**DPIE request for Advice - Glendell Continued Operations Project - SSD 9349**

I refer to your request via the NSW Major Projects Planning Portal for advice from Singleton Council on the Part A and Part B Response to Submissions Report (**Part A and Part B RTS Report**) for the Glendell Continued Operations Project (**SSD9349**).

FIGURE 3.2

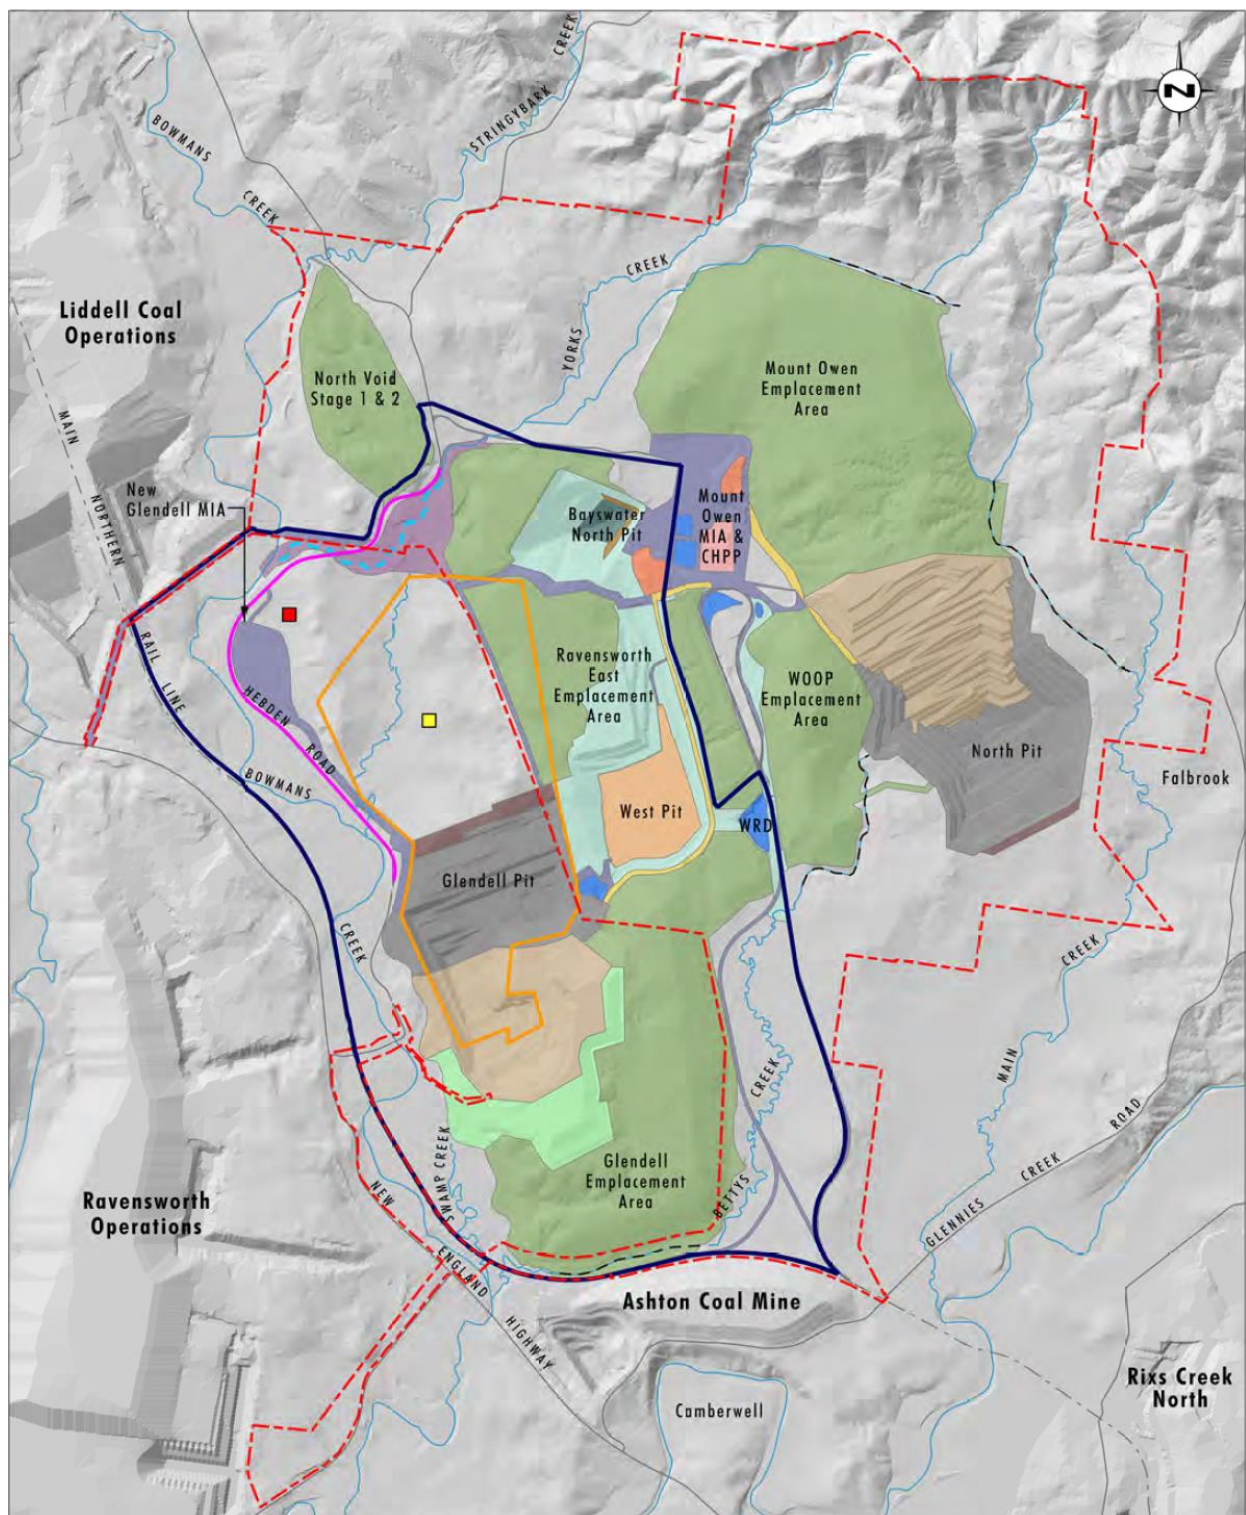
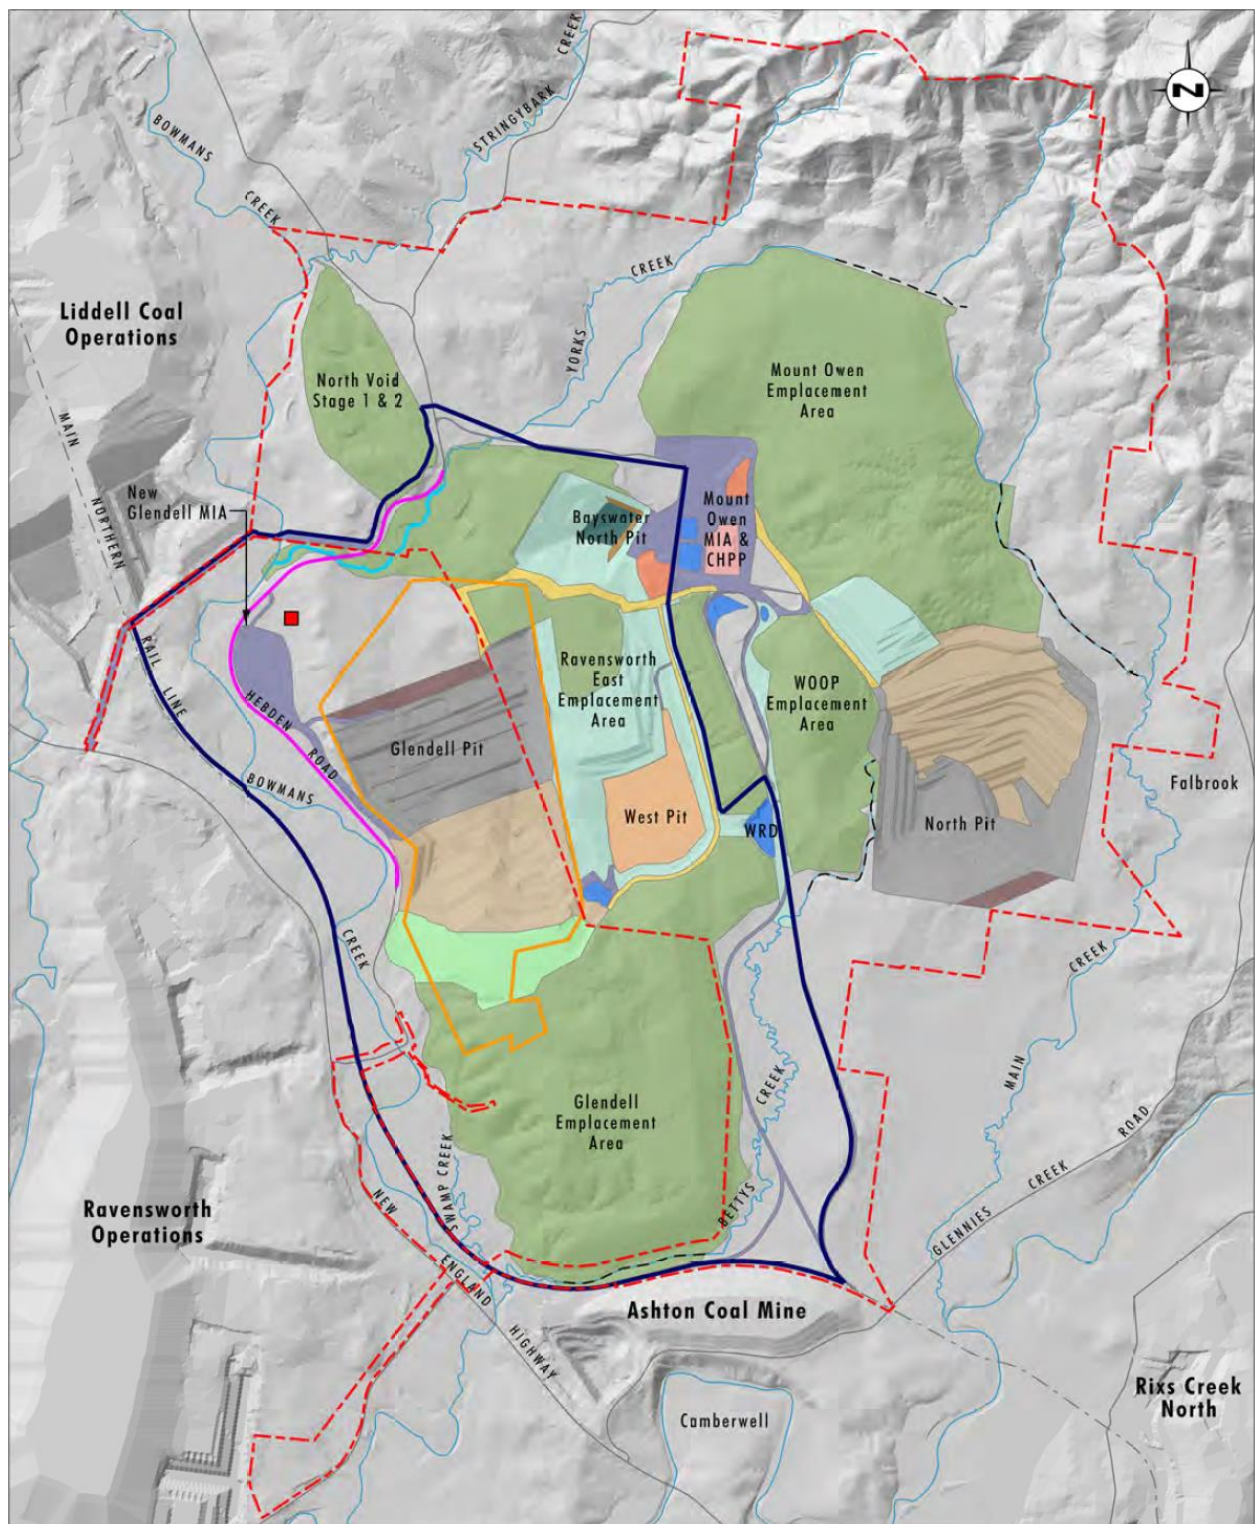
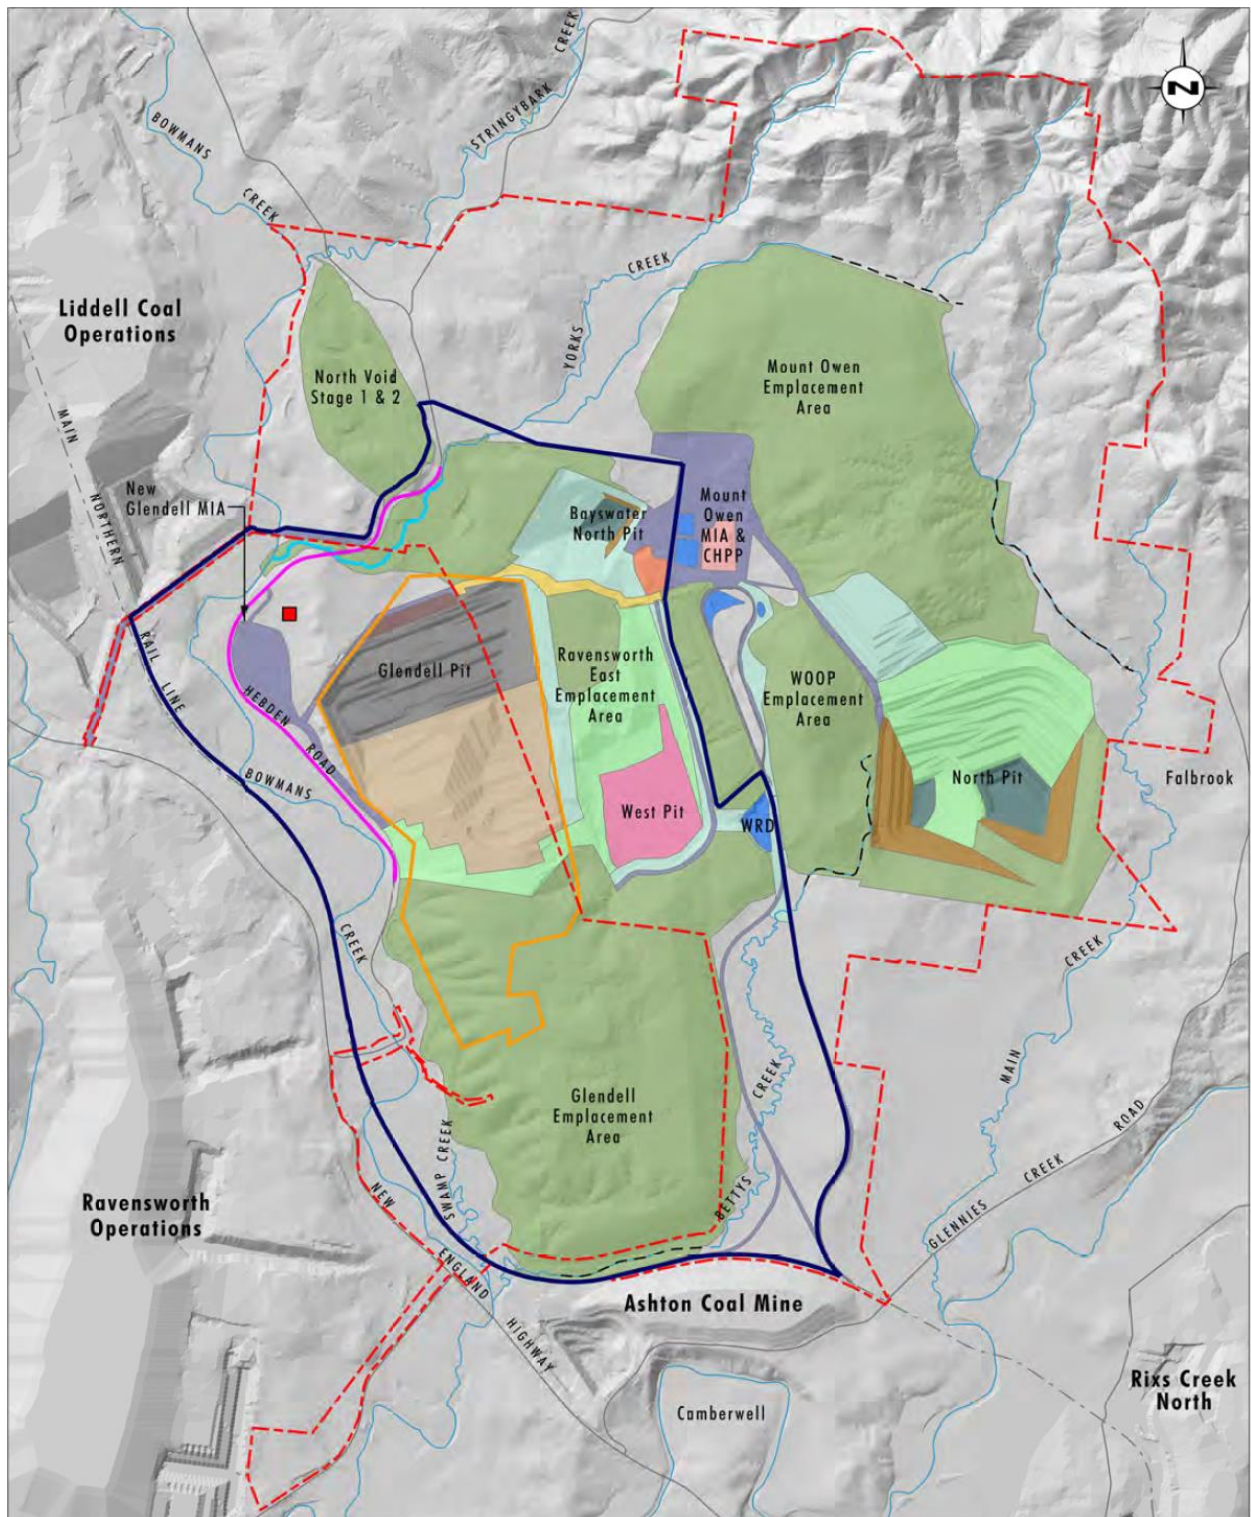
The RTS refers to section 3.2.3.2 and Figures 3.2 to 3.5 of the EIS to address this issue. Figure 3.2 to Figure 3.5 lack clarity on the relationship of overburden emplacement between each operation (Ravensworth, Liddell, Mount Owen and Glendell). The EIS does not provide a mass balance of overburden across the operations, to enable a determination on whether the volume of overburden produced across the complex will meet the proposed landform outcomes and anticipated final landform height.
